Sent: 20 March 2019 09:04
To: Planning Scanning
Subject: FW: AL/107/18/PL - Nyton Road

Landscape Officer Consultation Response.

Please see my comments below on the landscape proposals for application AL/107/18/PL.

PROJECT: NYTON STABLES, ALDINGBOURNE, WEST SUSSEX	DATE: AUGUST 2018
DRAWING: LANDSCAPE PROPOSALS	SCALE: 1:1250 @ A3
	DRAWN: CHECKED:
	DRAWING NO: 18307-2-101

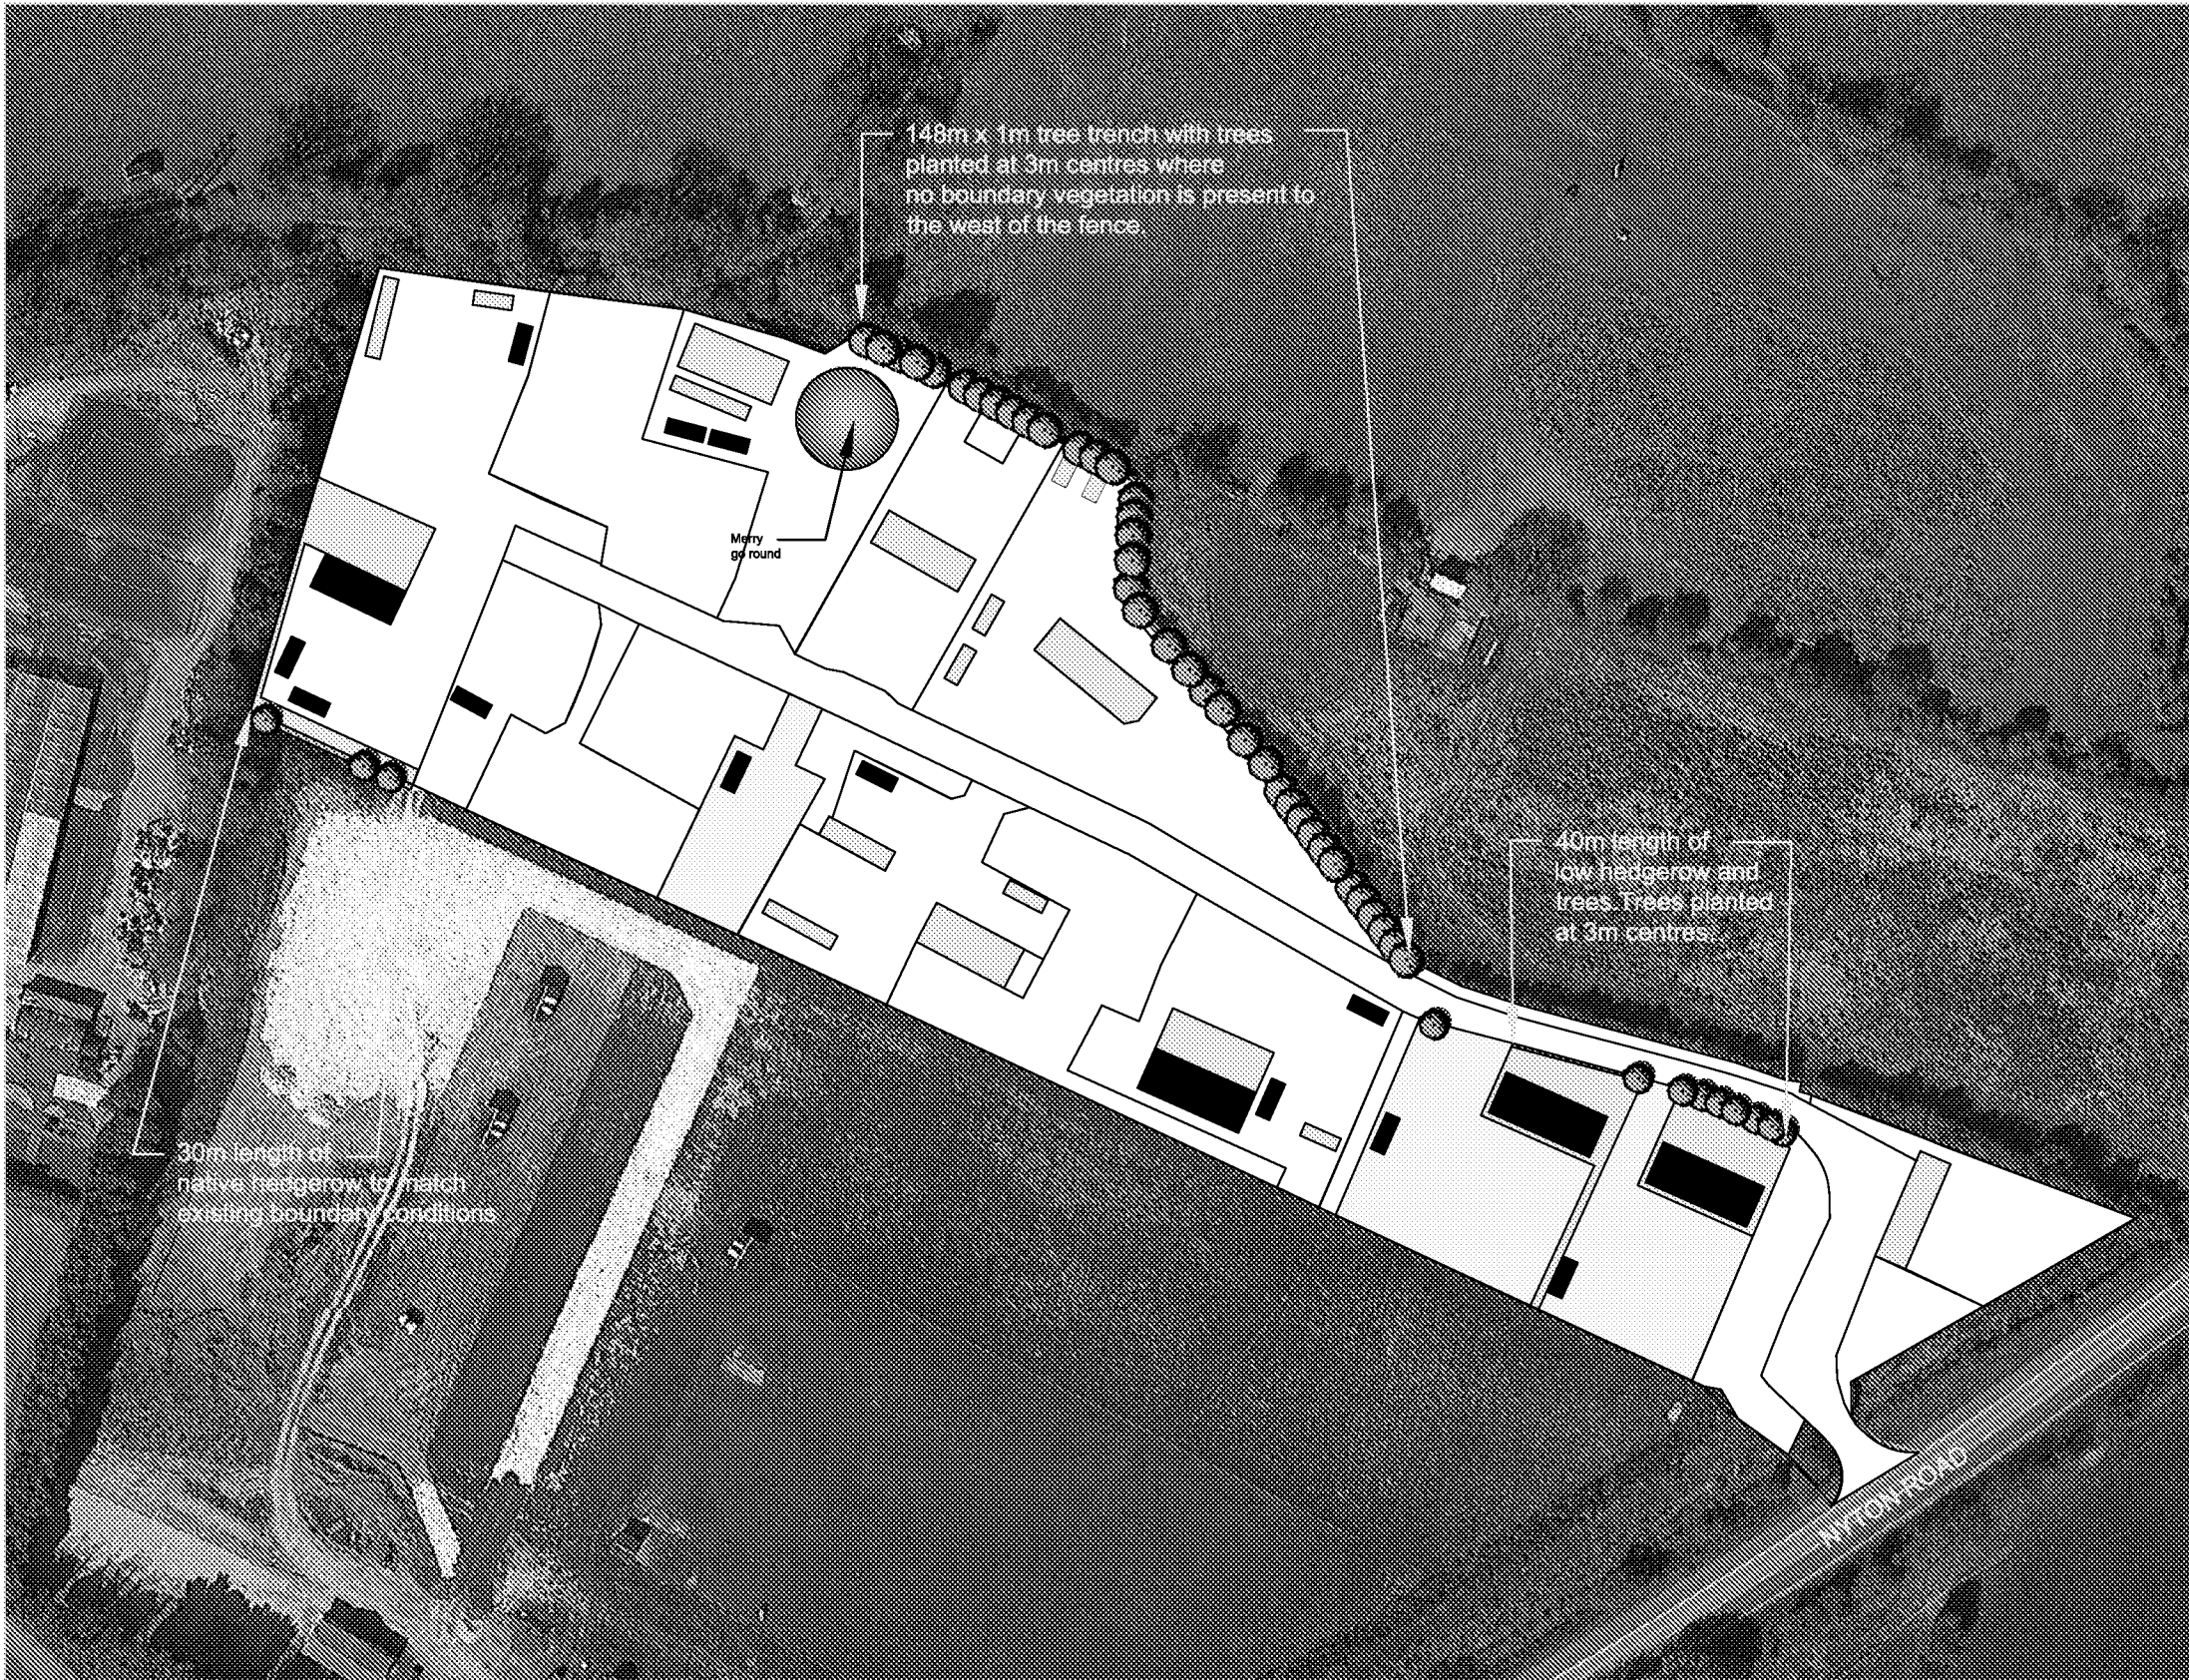
The additional trees which have been proposed under the current application will further enhance the screen to ultimately provide a double row of trees and a hedge. The pine trees will assist in screening views all year round particularly if planted in groups in the most sensitive locations. The crowns of the tree strip will filter views of the development site in the early years and the hedging will mature to provide additional cover above the boundary fencing as the trees increase in height. The new trees should be planted at staggered intervals with the existing trees to be most effective.

Further planting is required along the boundary closest to the public footpath due to the sparse nature of the boundary vegetation in the north-west corner of the site.

A more detailed planting plan at a larger scale is required to show the locations of both existing vegetation and proposed trees to ensure the existing gaps are appropriately planted. The plan needs to show details of species, sizes and numbers of all proposed trees. Some sizes are given but not against all species.
